DECISION DELEGATED TO HEAD OF PLANNING

Application No: H22-0325-22 **Applicant:** Persimmon Homes East Midlands

Proposal: Details of Construction Management Plan & Method Statement (Condition 4 of H22-1249-21)

Location: Land North West Of High Road Weston Spalding

Drawing:
Construction Management Plan

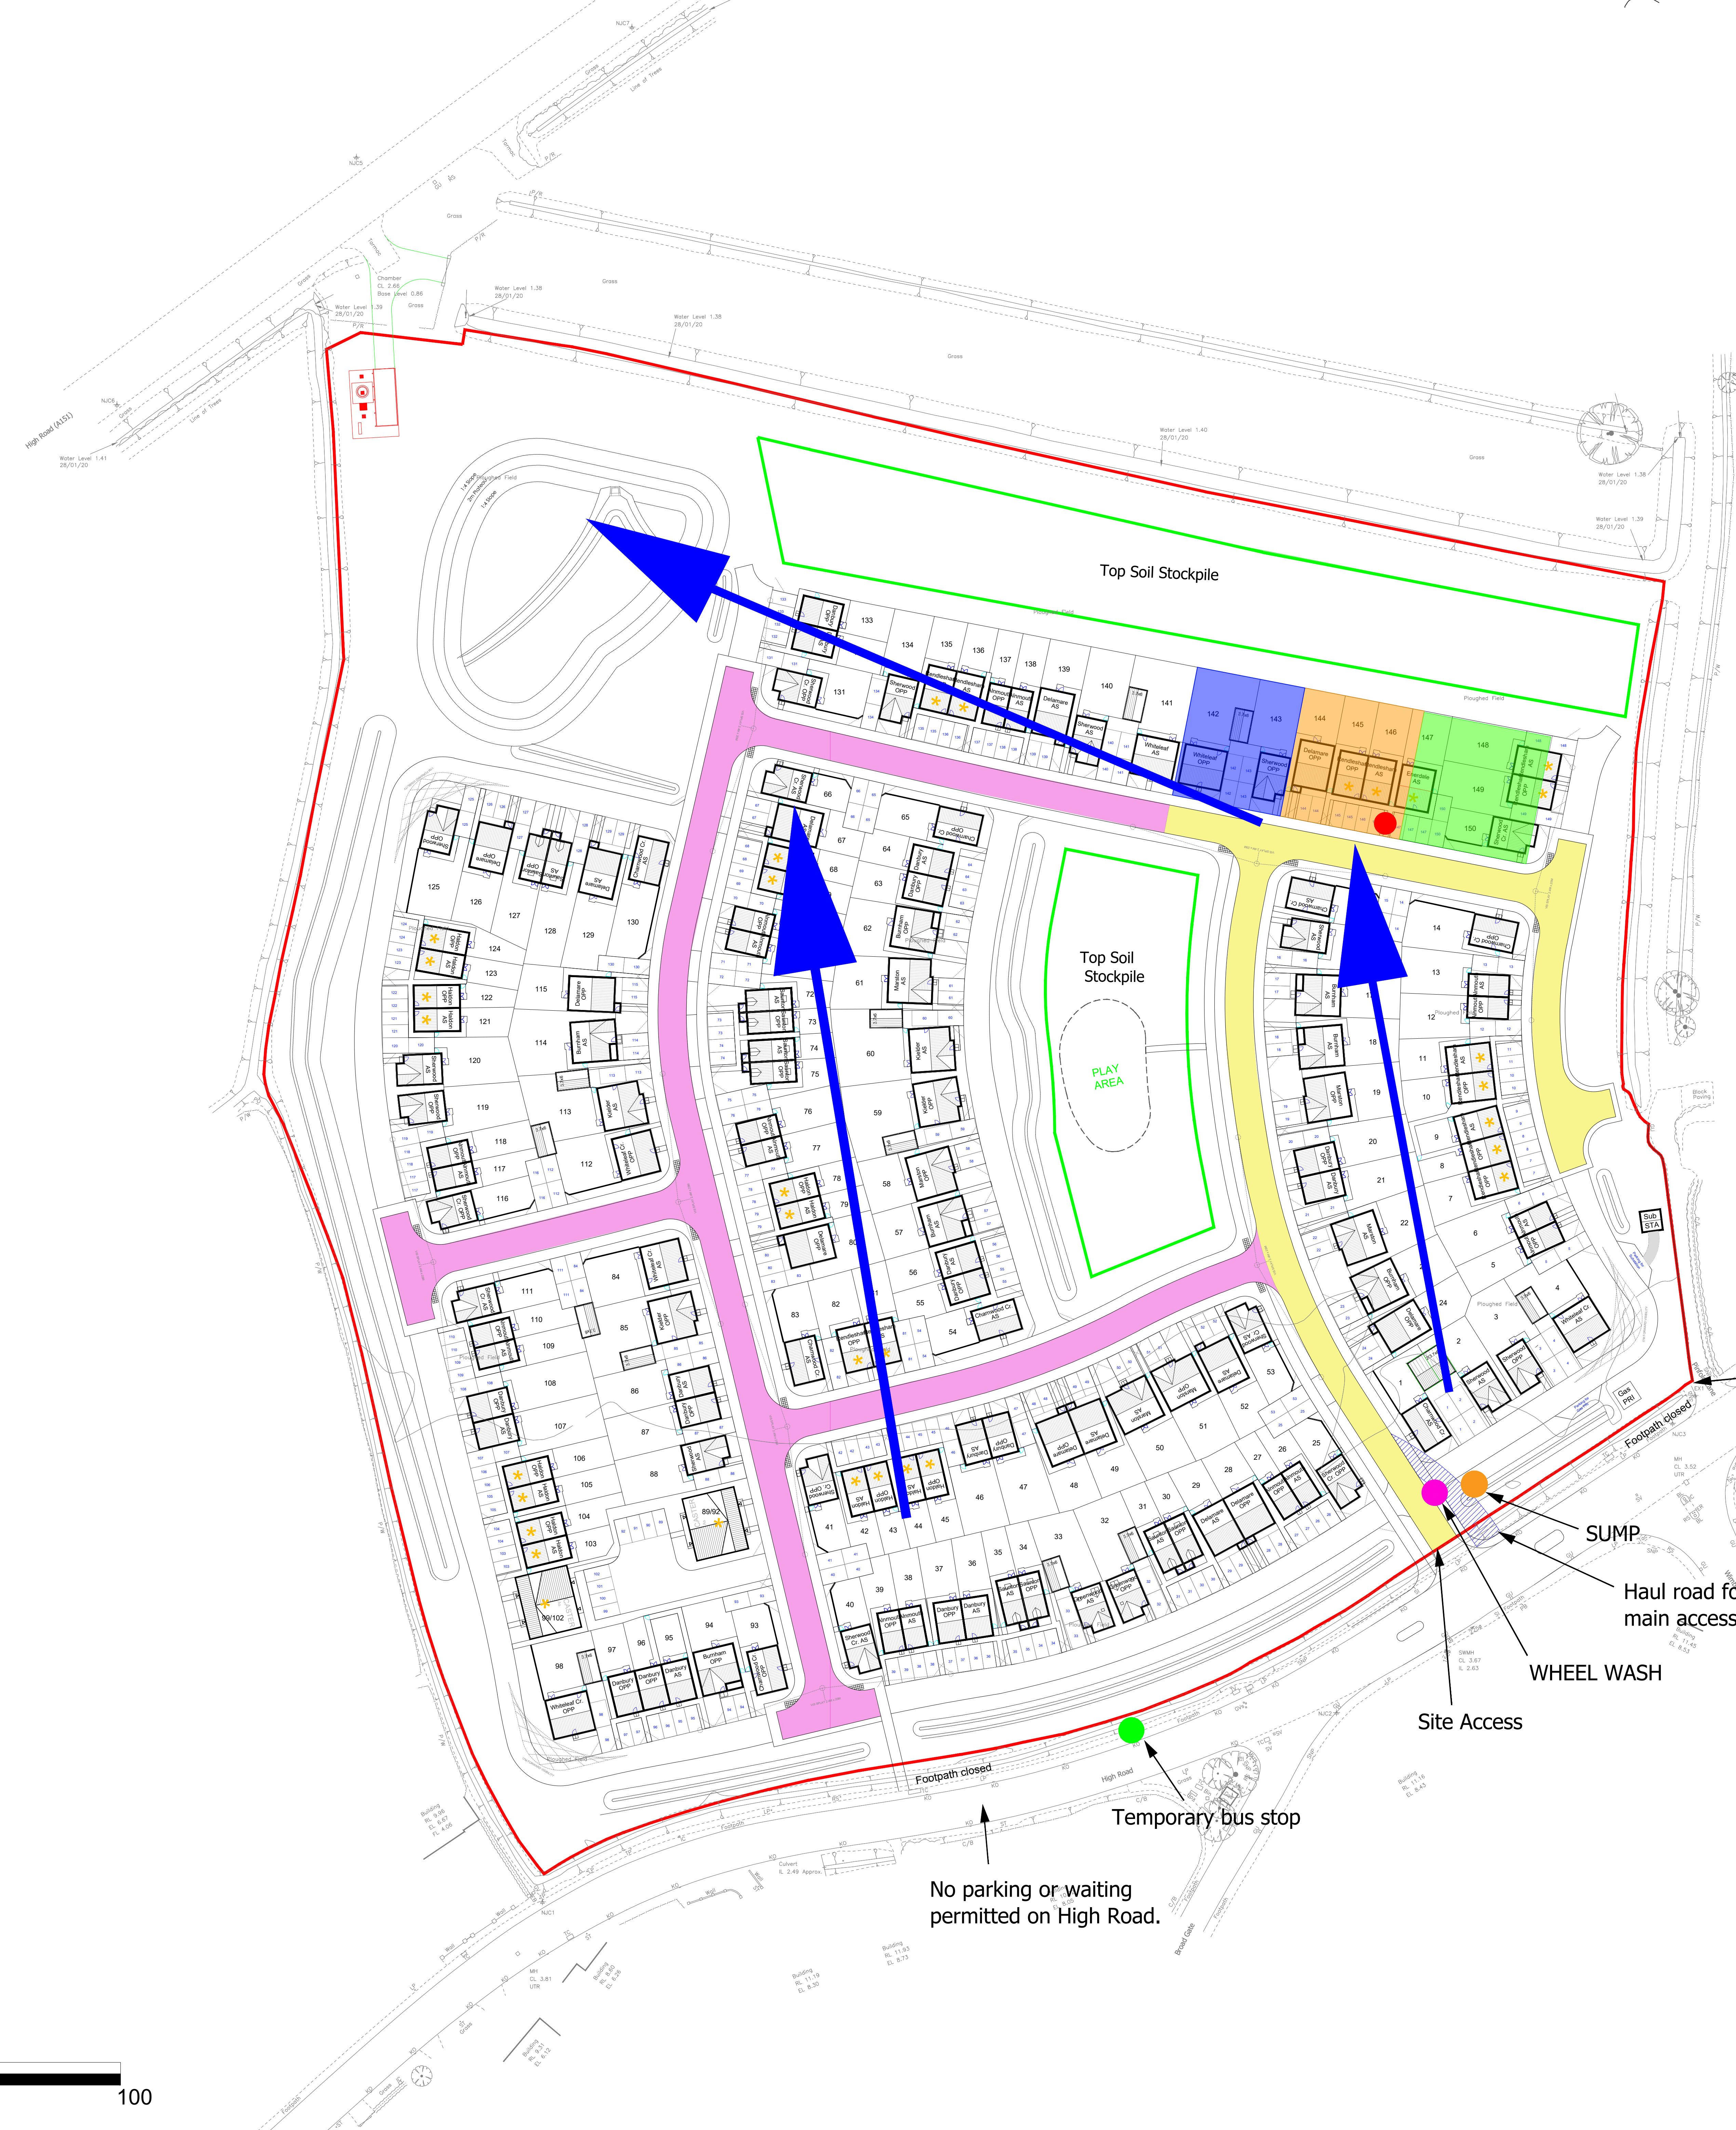
- Bypass was designed and intended for heavy vehicles to eliminate high and heavy use through the village
- No condition imposed on application to prevent use of High Road and require access from bypass.
- We are now seeing and going to see the road broken and deteriorate, noisier, more traffic and dirtier
- No consideration was given to the existing residents and property owners in the area.

In the opinion of the Highway Authority, it would be considerably less desirable for construction vehicles to access the site from the bypass which is an unrestricted road, whereas High Road is a 30mph road. High Road also used to be the main through road prior to the bypass being constructed and therefore there is no particular highway reason why it is not suitable for construction traffic.
